**From:** Mau, Russell E (DOH) <Russell.Mau@DOH.WA.GOV>  
**Sent:** Wednesday, October 8, 2025 8:49 AM  
**To:** Ellie Myers  
**Cc:** Melissa Schumaier  
**Subject:** RE: SD-25-00001 Easton Research and Rearing Facility Outfall - Notice of Application

The Department of Health (DOH) Office of Drinking Water (ODW) has reviewed the application and has the following official comments:

SITE PLAN - SOUTH

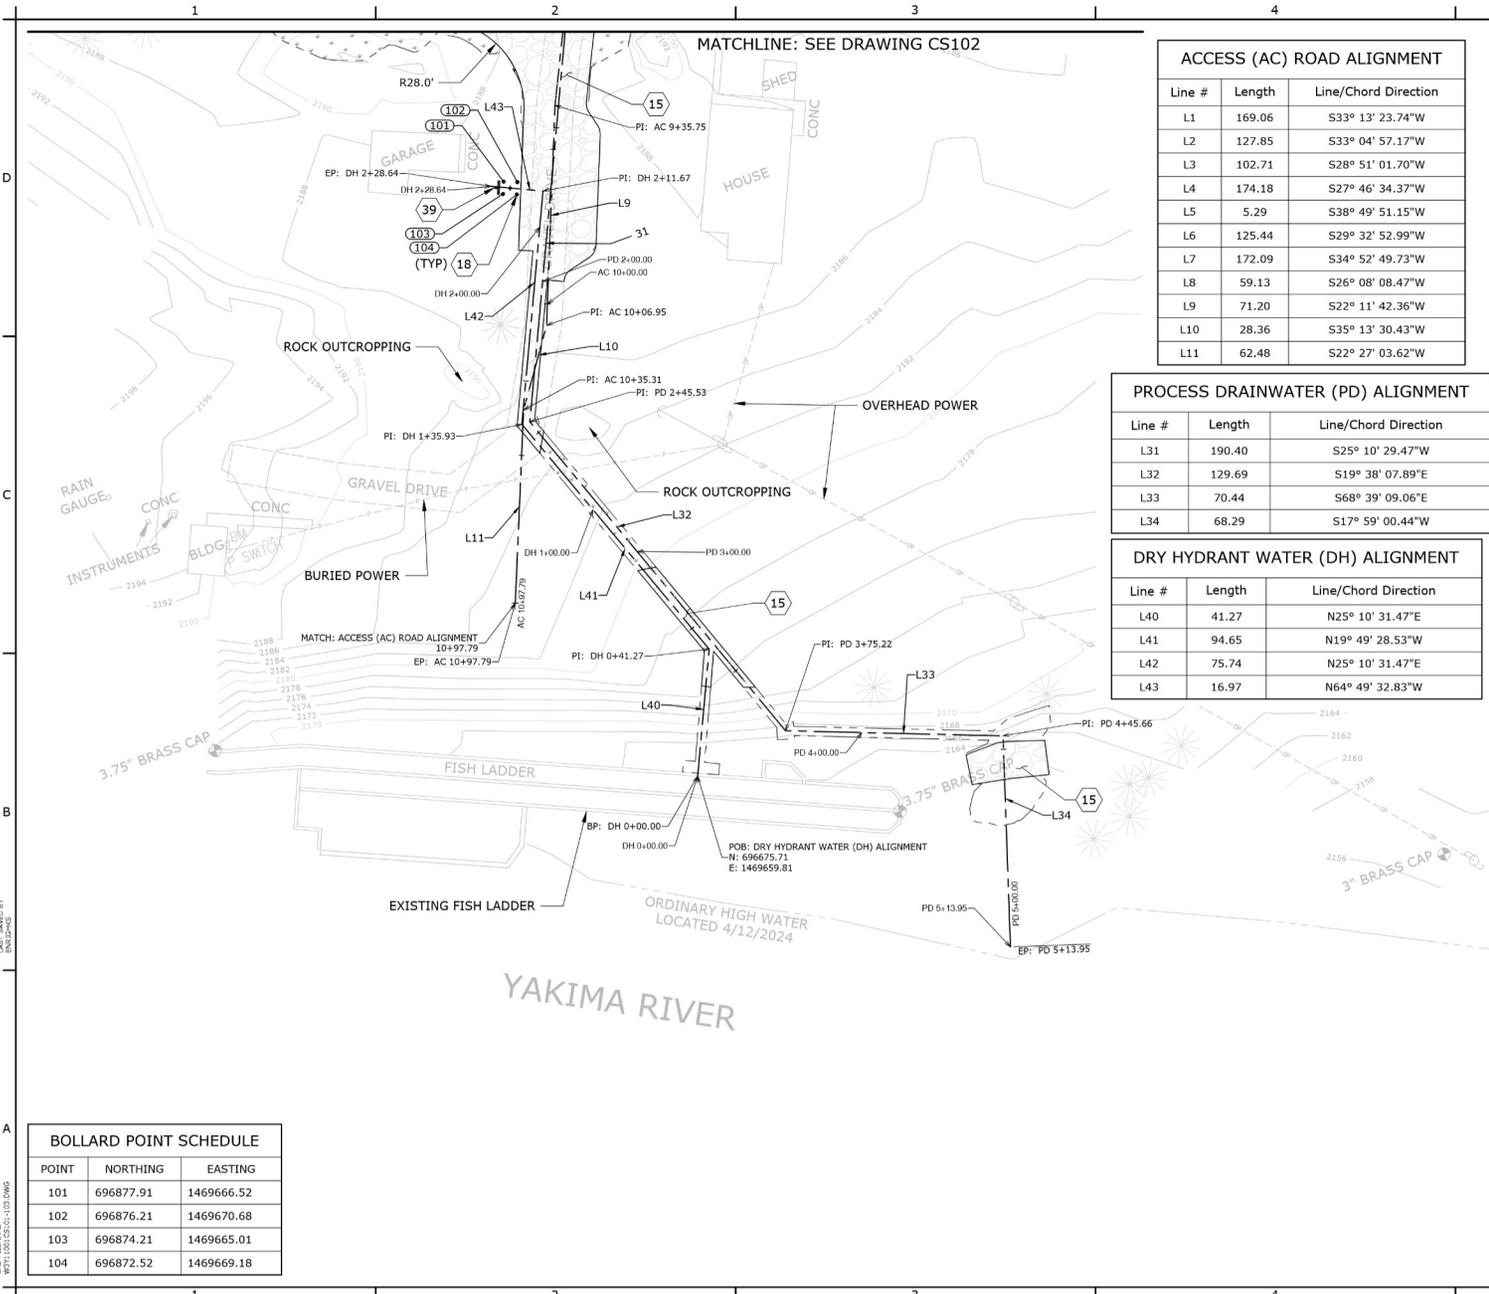
1. The applicant proposes a new groundwater well to provide water, for “drinking” water uses, within the proposed building – DOH ODW seeks the following information:
  - Is the proposed property within the service area of the “Easton Water District” (ID #42700)?
  - What is the number of persons who will be on-site per day and per month?
